Consultation Response KC Landscape

Planning Number:	2025/91184		
Proposal:	Erection of two storey industrial unit (Use Class E(g)(iii)), with associated car park, service area and other associated works		
Location:	land off, Bretton Street, Savile Town, Dewsbury, WF12 9BZ		
DEVELOPER/APPLICANT/AGENT:	Jade3 Architecture		
Planning Officer:	Jillian Rann		
Date Responded:	20.08.2025	Responding Officer:	Landscape
Site Area (Hectares)		Responding Ref:	PP34

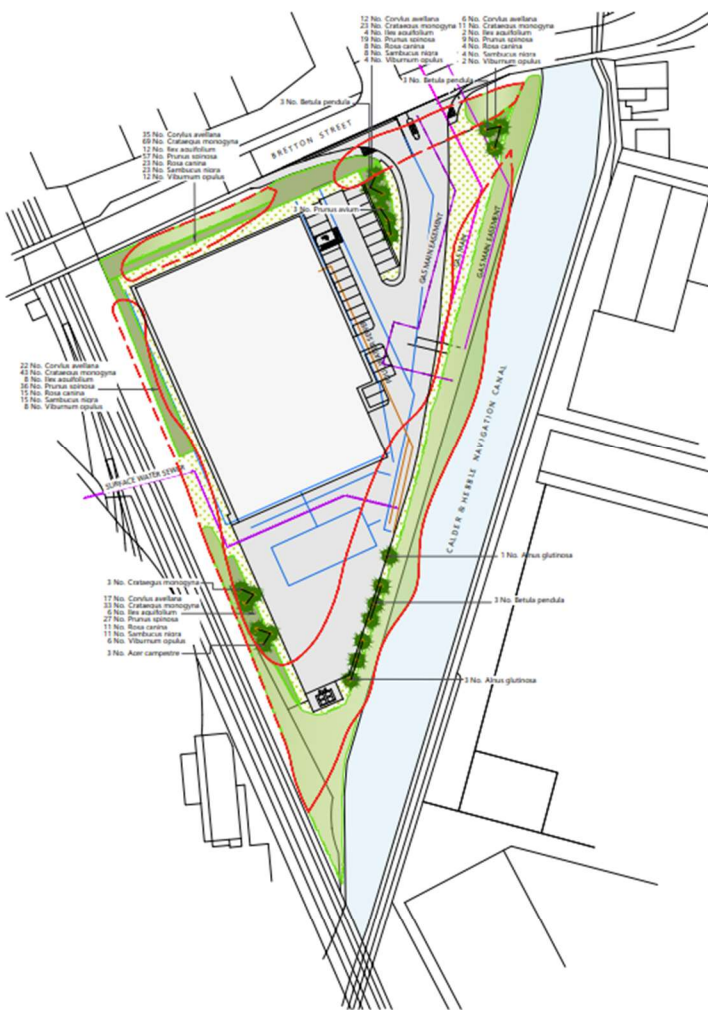
3. Will there be any trees retained along the Canalside? Potentially due to new gas alignment/ easement?

4. Confirmation required that new tree planting will not be adversely affected/necessitate removal by this easement.

5. We cannot see the aftercare maintenance or a landscape maintenance and management plan to accompany the landscape planting scheme, however. This should be provided and for the aftercare maintenance to provide any meaningful benefit to the establishment of the landscaping scheme, it needs to ensure that the period for maintenance is for five years after the initial implementation, including any like for like replacements for plant and tree loss/failure.
